Project: Great Wolf Lodge, Chesterton  
Prepared by: Kathryn Lewis  
Approved by: David Lewis  
Date: 7<sup>th</sup> February 2020

- 1.3 Following submission of the planning application comments have been provided by the Chesterton Parish Council (CPC) in respect of the submitted planning application including a letter provided by Paul Basham Associates (PBA). This Technical Note has been prepared in response to the comments from the CPC and PBA and provides further details in relation to the sustainability of the site, walking and cycling improvements, shuttle bus provision, the proposed site access and the impact of the development proposals on the wider highway network. It sits alongside and as an appendix to the letter prepared by DP9.

Title:  
Proposed Access Arrangement

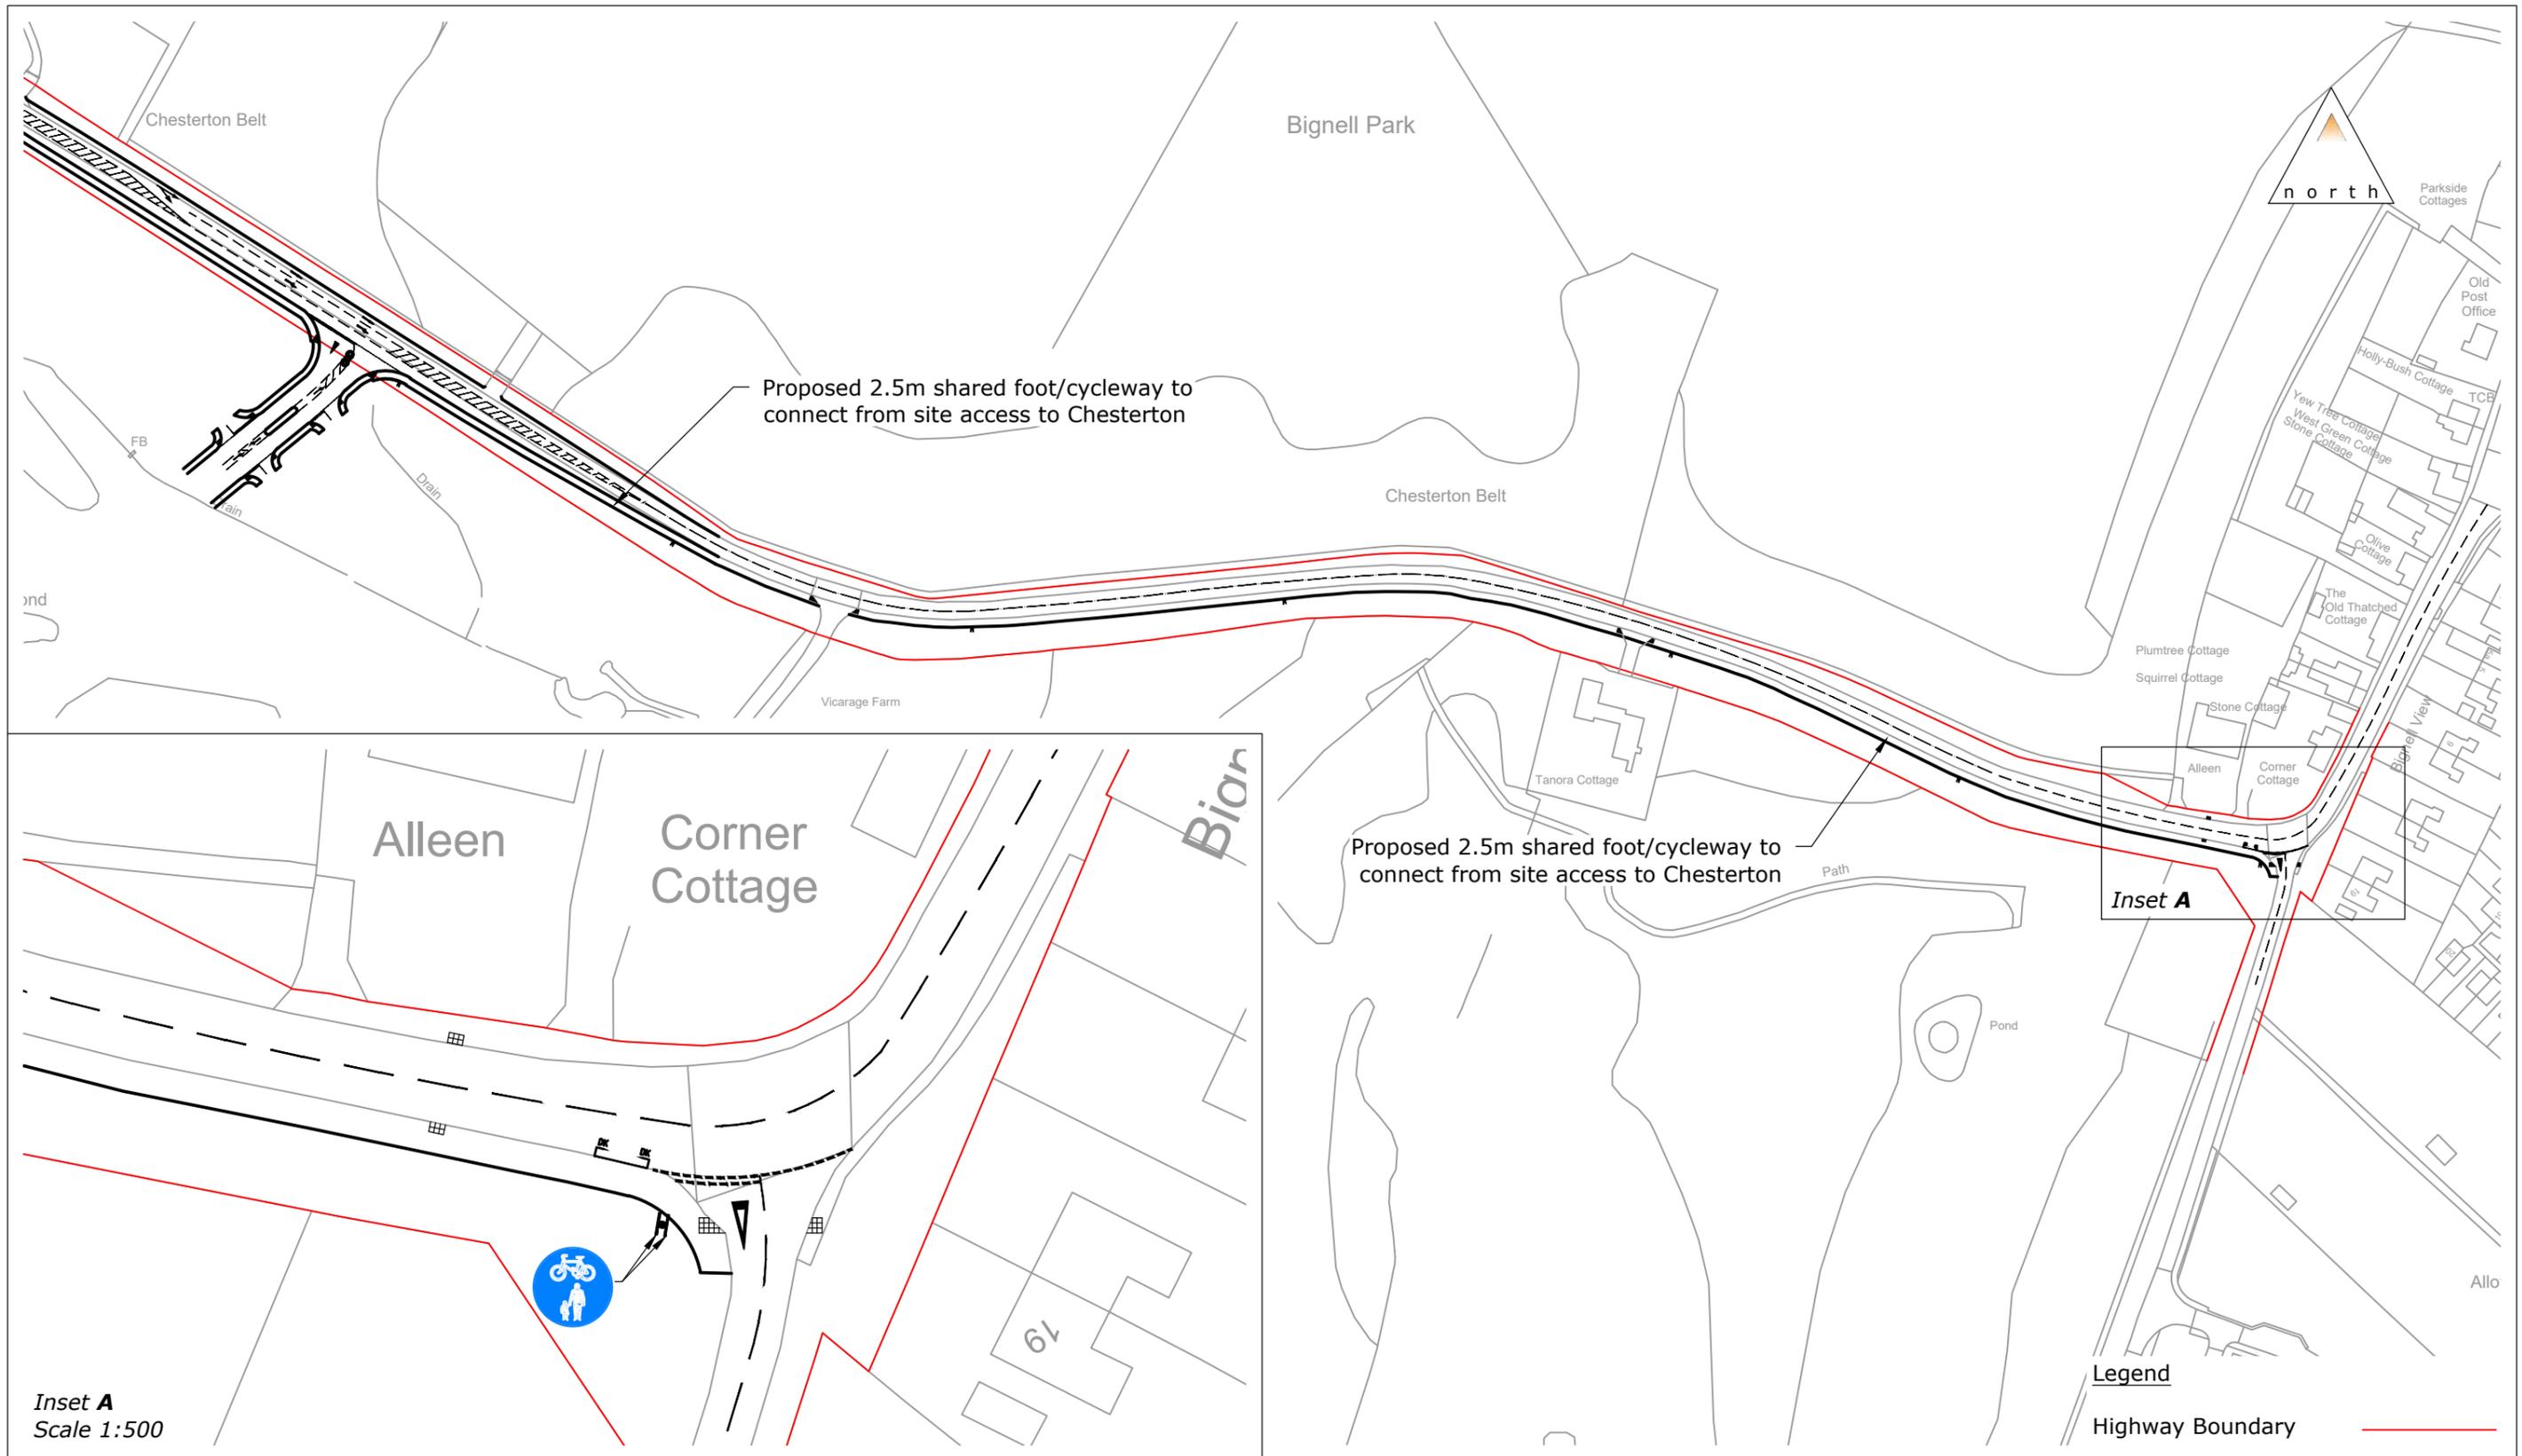
- 2.5 It is proposed that the development is accessed via a new priority junction, with right turn ghost island, from the A4095. The layout of the site access junction, including the visibility splays achieved, have been designed with reference to the Design Manual for Roads and Bridges guidance and scaled plans were provided as part of the Transport Assessment which allow geometries of the junction to be measured. OCC have reviewed the design of the site access junction and have confirmed that the design is acceptable.
- 2.6 It is not a requirement of OCC to provide a Road Safety Audit at the planning stage and a Road Safety Audit will be undertaken as part of the detailed design of the highway works, should planning consent be granted.

- 2.9 Following discussions with OCC it is now proposed that an additional stretch of footway of circa 370 metres in length along the A4095 west of the proposed site access junction, either side of the motorway overbridge, to connect with PRoW 161/11 to the west. This provides a betterment to the existing connection between PRoW 161/06 and PRoW 161/11, providing pedestrians with a footway, where they are currently required to walk within the grass verge to connect between PRoW 161/06 and PRoW 161/11. The proposed extended footway is shown on Drawing 1803047-03, attached at [Appendix A](#).

- 2.15 It is therefore concluded that the proposed new footway and shared foot/cycleways detailed on Drawings 1803047-03 and 1803047-15 provide a betterment over existing conditions for pedestrians and cyclists and provide improved connectivity between PRoW 161/06, 161/11 and Chesterton to the betterment of access to the site and for local residents and future users of the proposed development.
